Project Name: VOLCANO CLIFFS SUBDIVISION, UNIT 3

DEVELOPMENT REVIEW BOARD – SPEED MEMO

DRB CASE NO/PROJECT NO: 1003907

RE: Volcano Cliffs Subdivision, Unit 3/minor plat

PLAT OF
 LOTS 1-A-1 & 1-A-2, BLOCK 5
 VOLCANO CLIFFS SUBDIVISION, UNIT 3
 SECTION 27, T. 11 N., R. 2 E., N.M.P.M.
 CITY OF ALBUQUERQUE
 BERNALILLO COUNTY, NEW MEXICO
 JANUARY 2005
 SHEET 2 OF 2

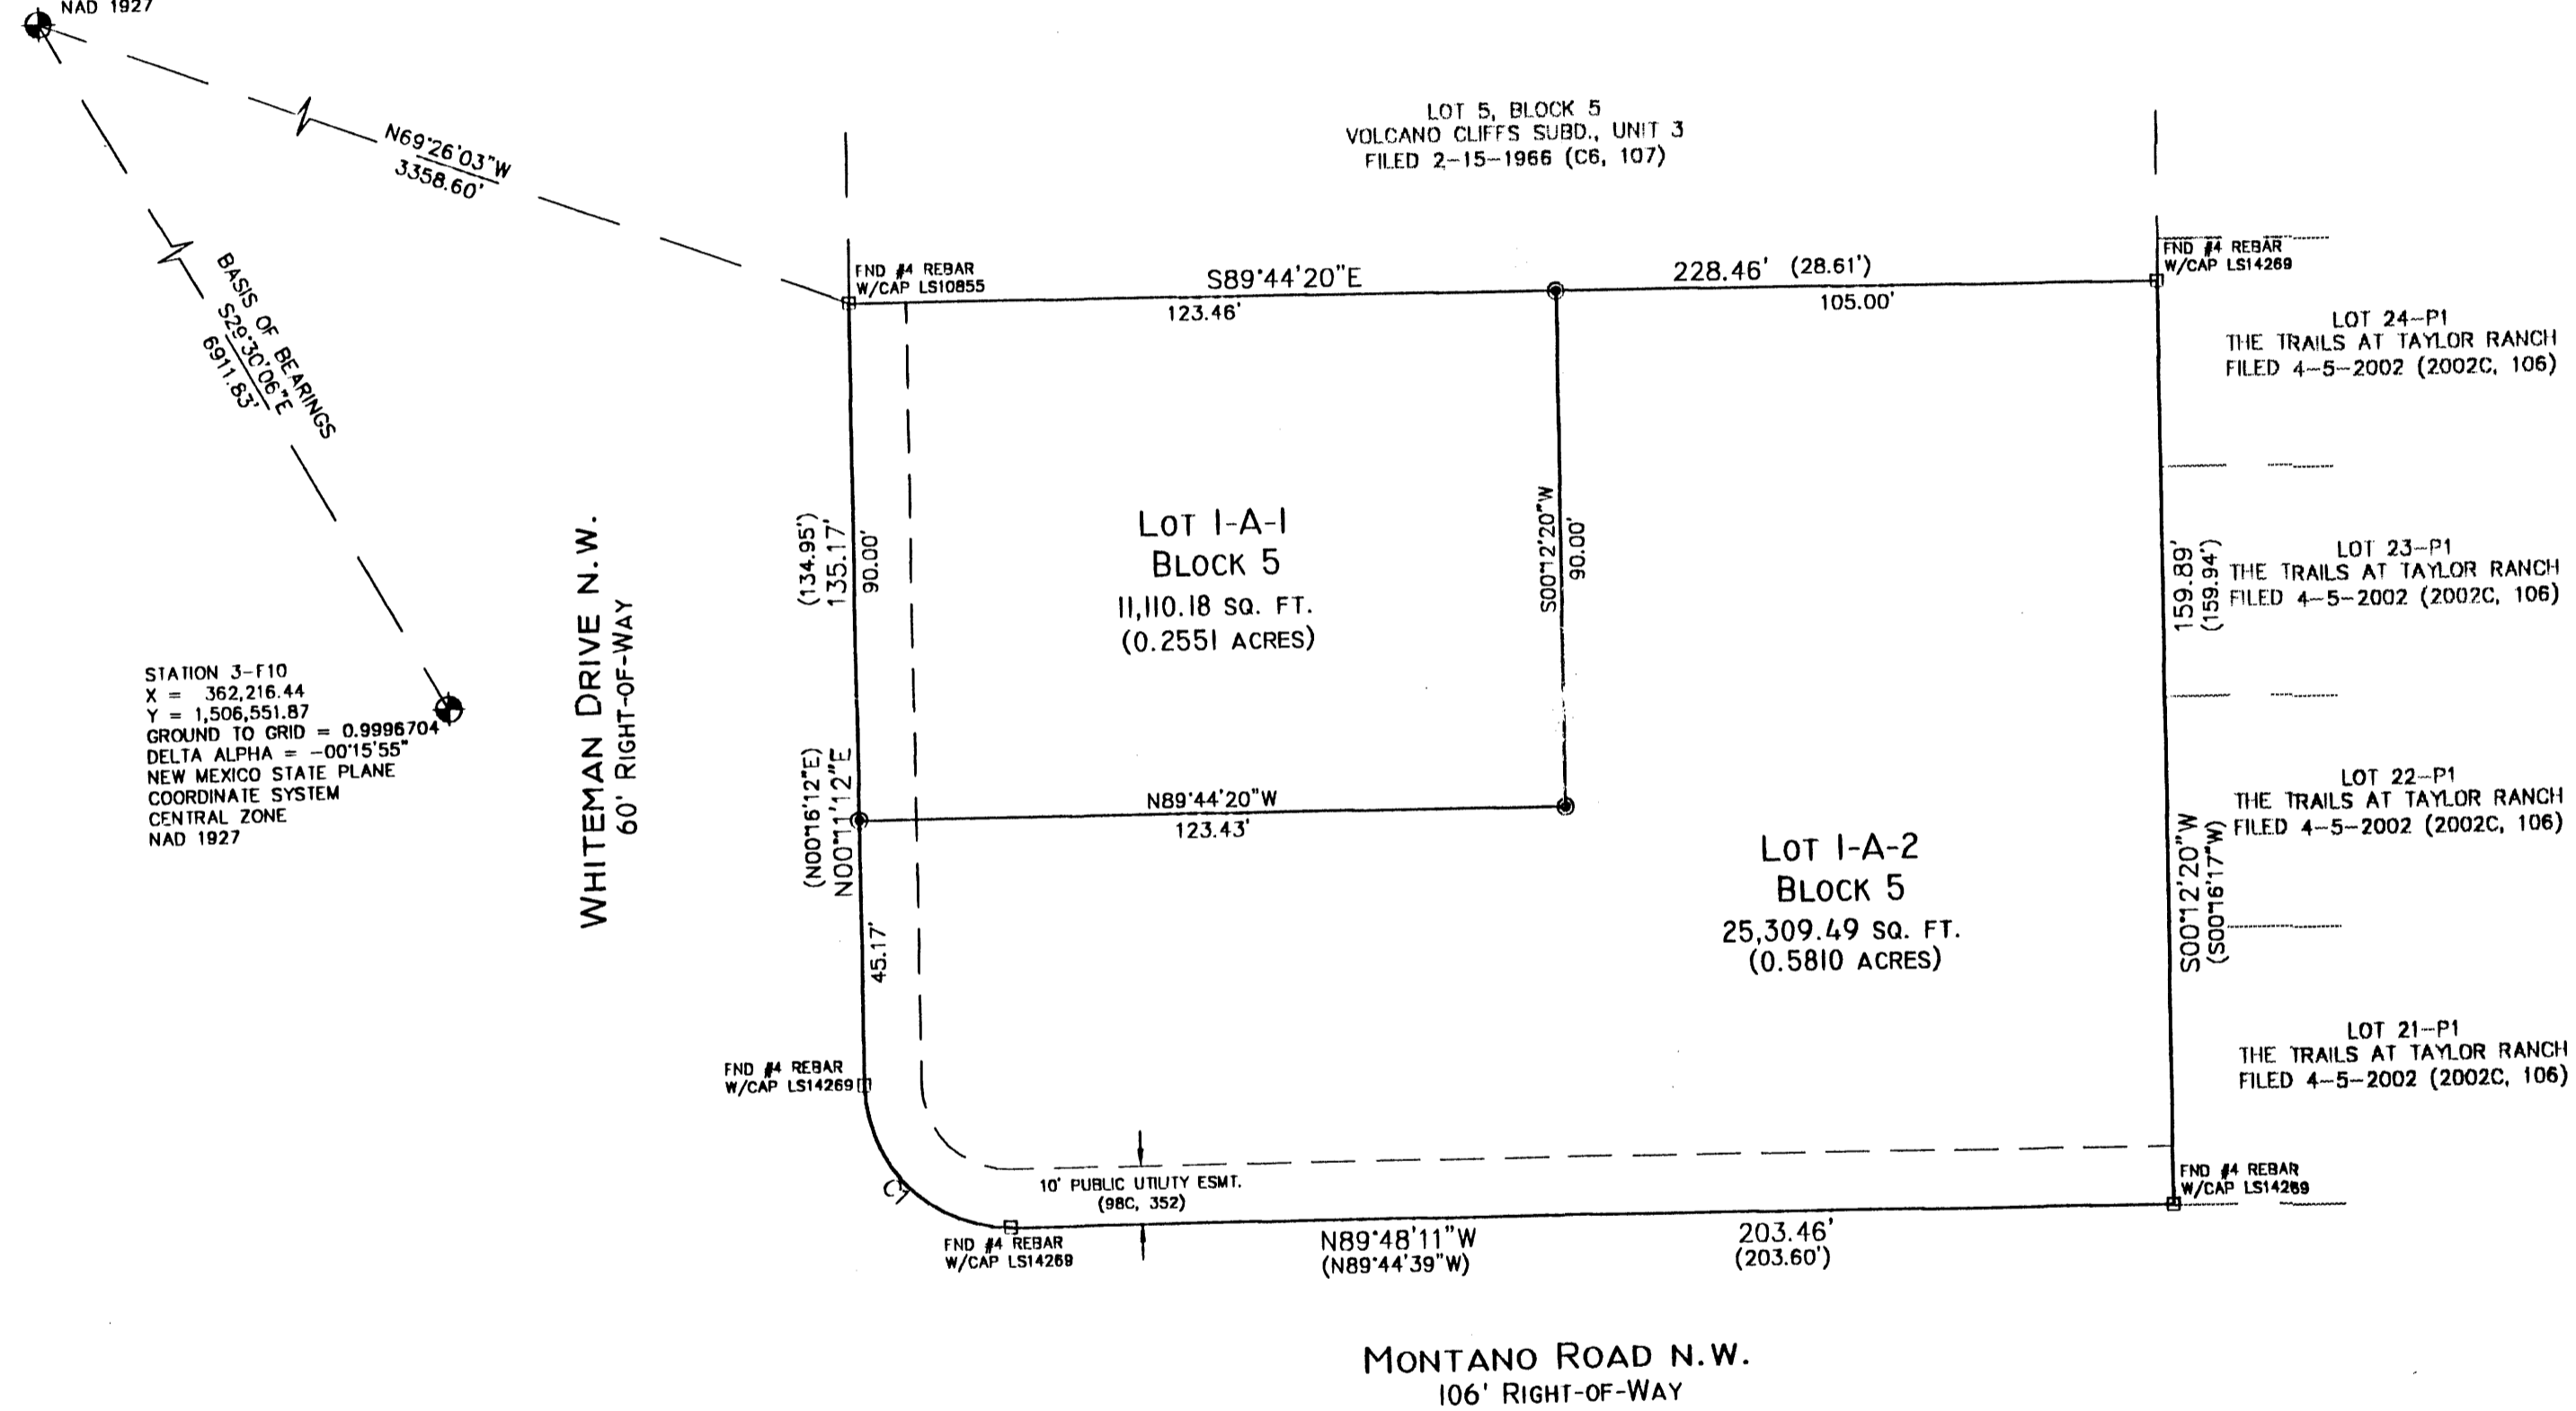
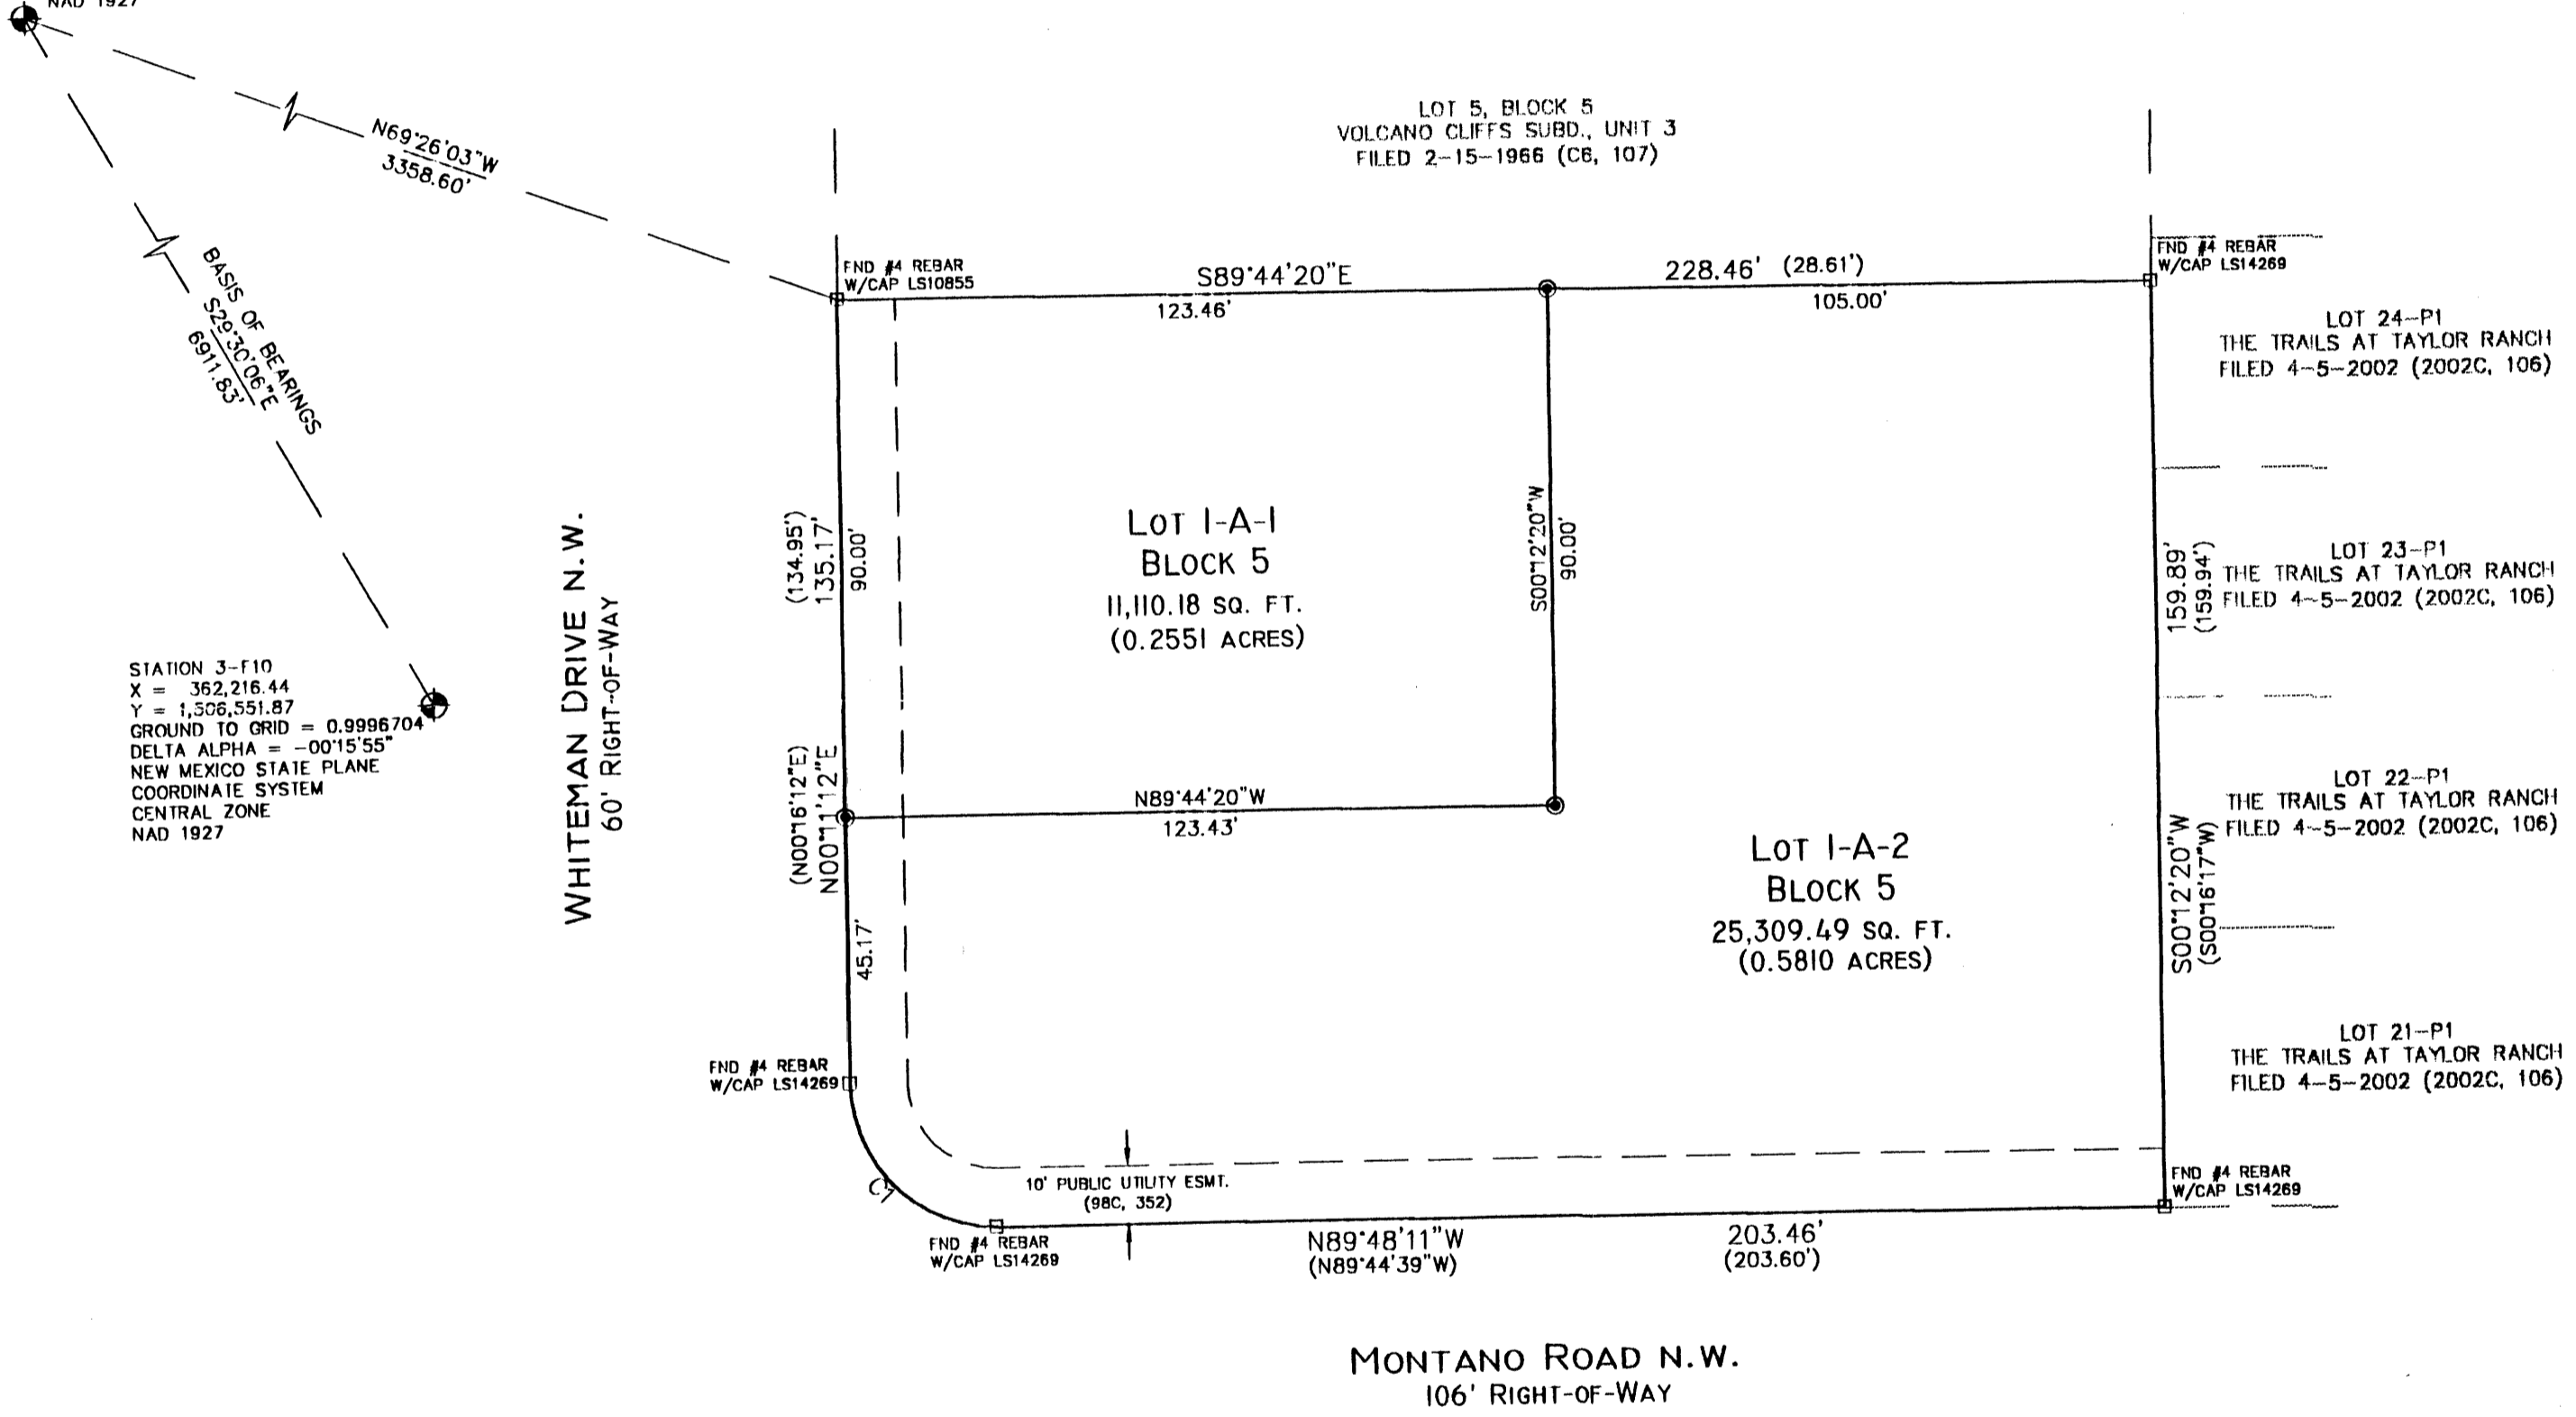
CITY ENGINEER / AMAFCA: _____
~~_____~~ reciprocal cross-lot drainage easement (ok)

A reciprocal cross-lot drainage easement is required.
